Ribble Valley Borough Council
By email

Your ref 3/2025/0801
Our ref DC/25/3013
Date 11-DEC-25

Location: Land to east of Salesbury View Wilpshire

Proposal: Proposed erection of new residential development comprising 80 new homes, including 30% affordable housing, open space and associated infrastructure.

Drawing Title
**DRAINAGE LAYOUT
SHEET 1**

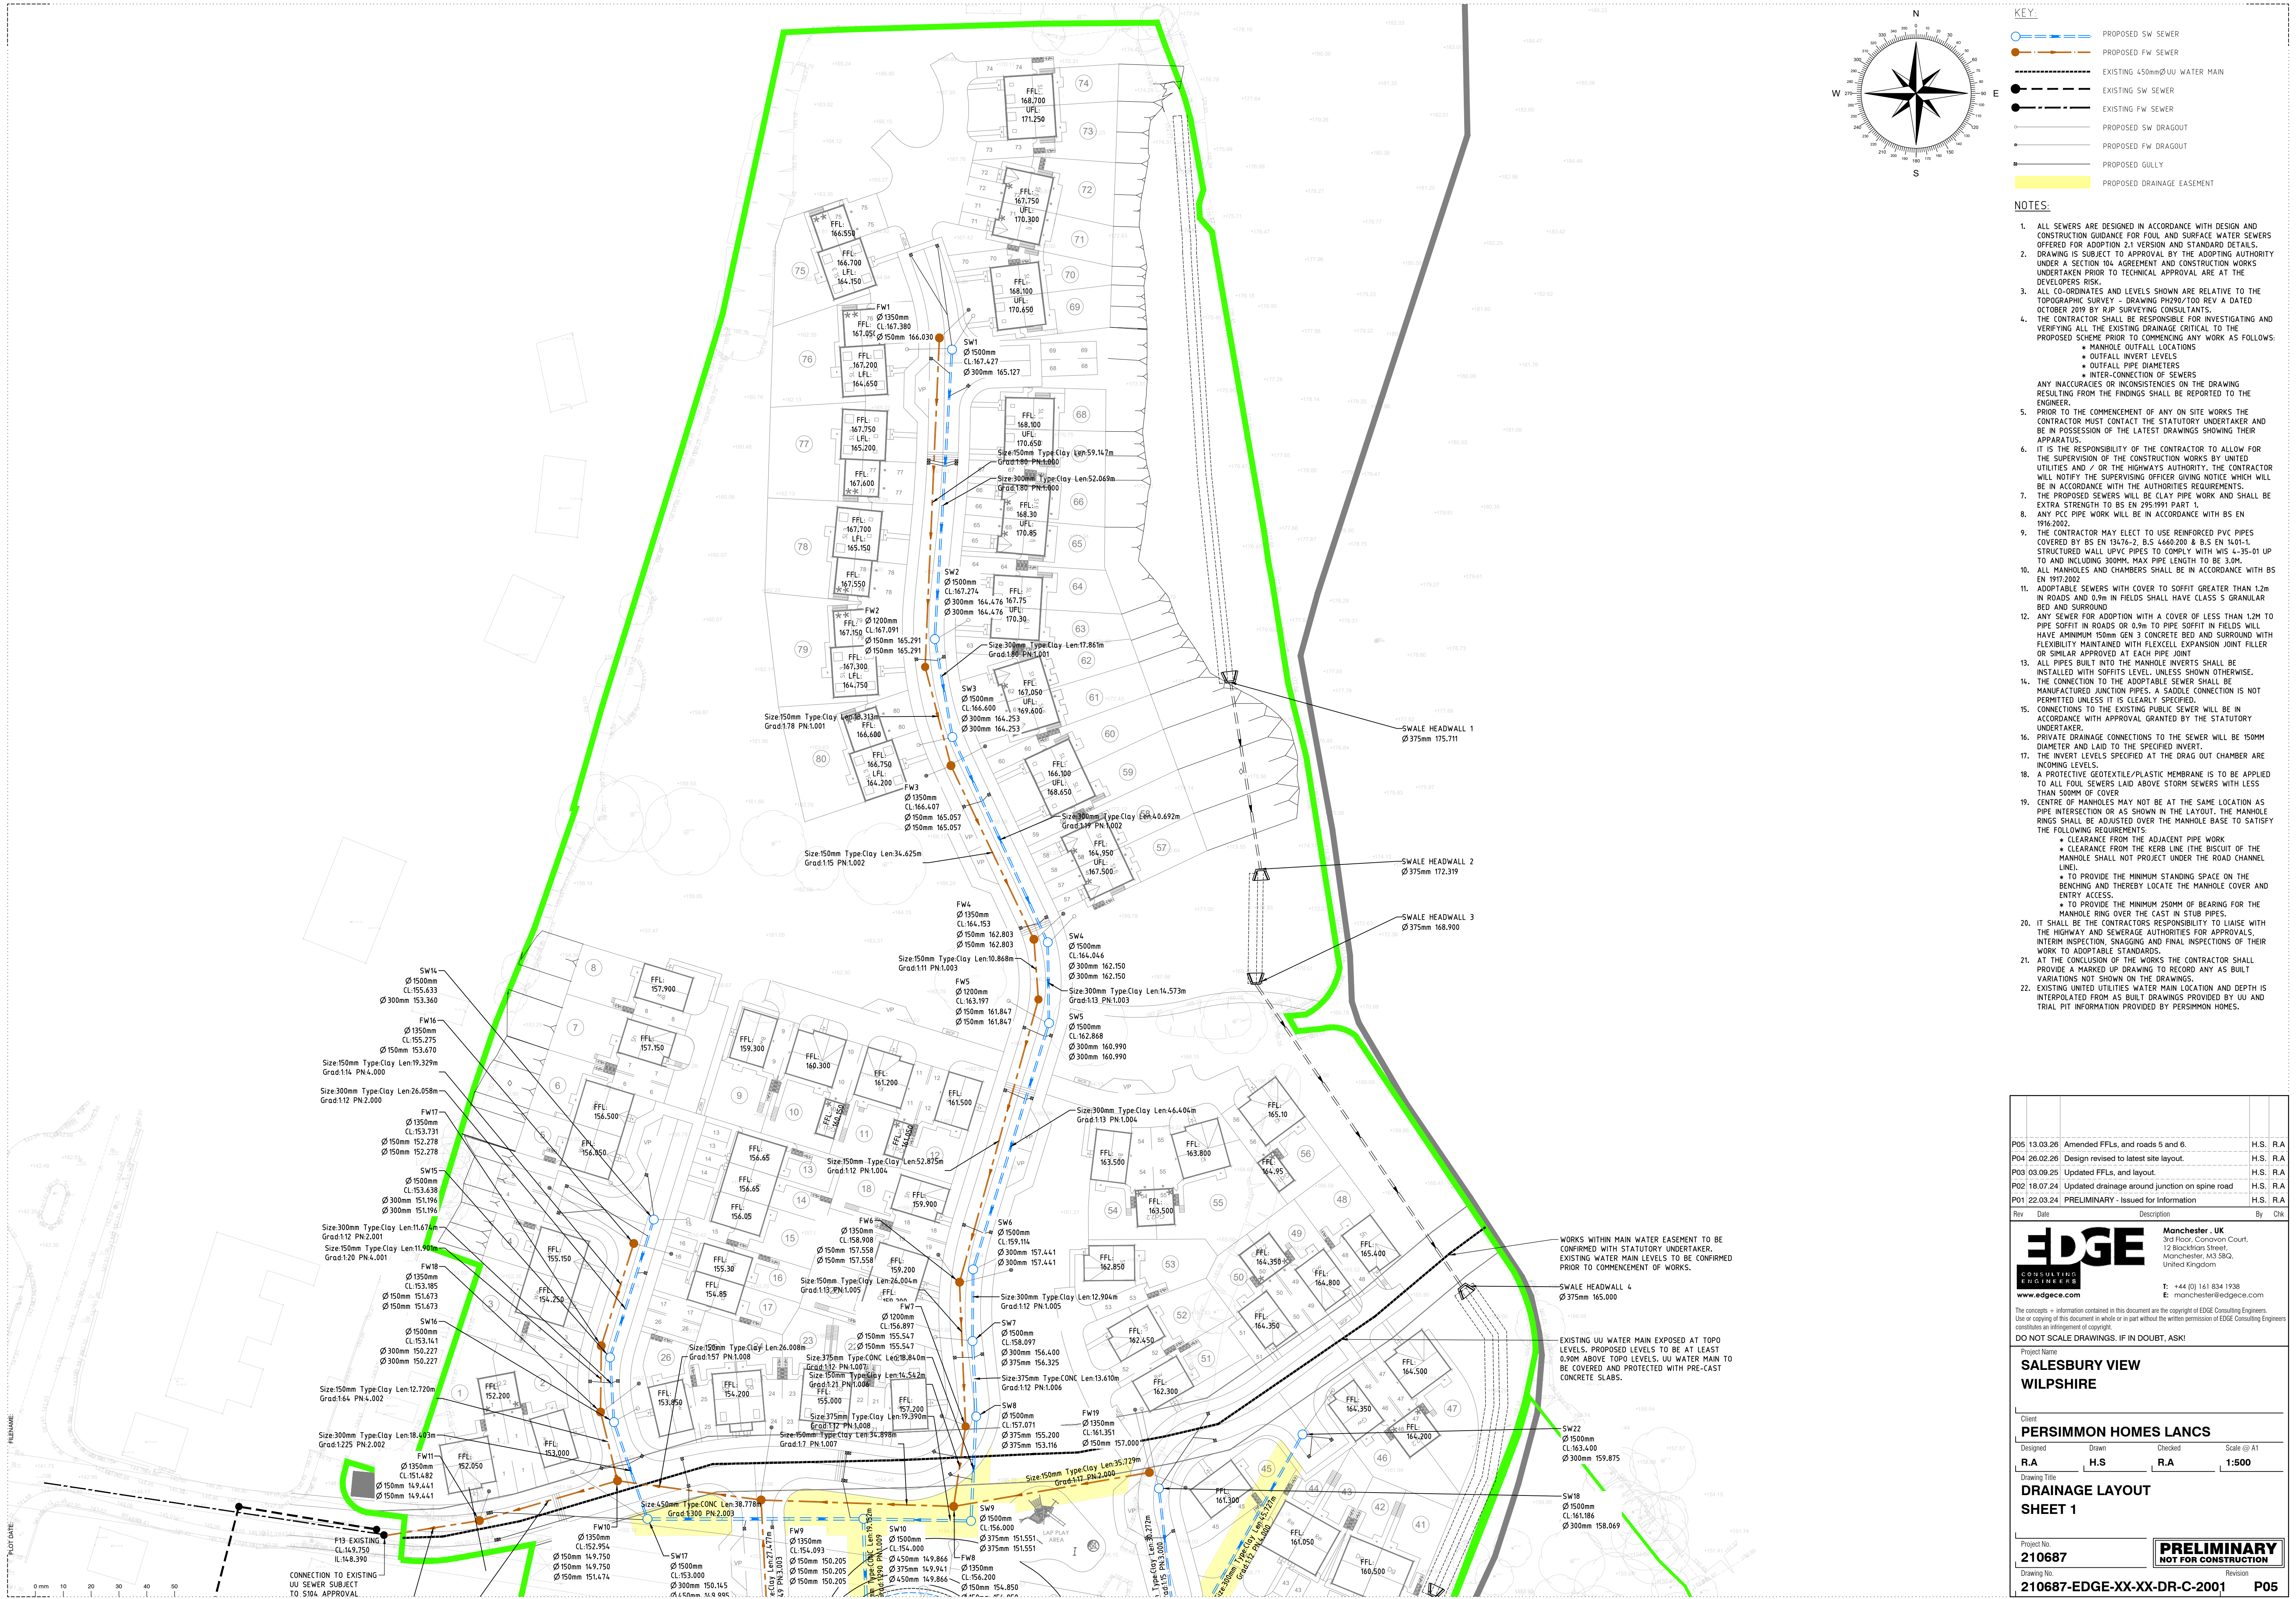
Following our review of the submitted Drawing Ref: 210687-EDGE-XX-XX-DR-C-2098, Rev: P11 Dated 22.10.25 , we can confirm that whilst the strategy for the disposal of foul and surface water is acceptable in principle, there are elements of the detailed drainage design that might not be acceptable to United Utilities and will require resolution by the applicant.

For example, there appears to be cover levels of adjacent manholes that are higher than finished floor levels of properties. For this reason, and to avoid any unnecessary delays or costs for the applicant, we request that the **proposed drainage strategy is not approved** until such time as all concerns are resolved. The applicant should contact our Wastewater Developer Services team regarding this matter. See Appendix, Section 6.0 Contacts.

Following our review of the proposed site layout, we request the applicant provides evidence that the water main shown on the site layout plan, has been accurately located by site survey. An extract of asset maps will not suffice. Due to the size of the water main, we strongly recommend this matter is resolved PRIOR TO THE SCHEME BEING DETERMINED. Without resolution of this matter before determination, our position must be to OBJECT to the proposal.
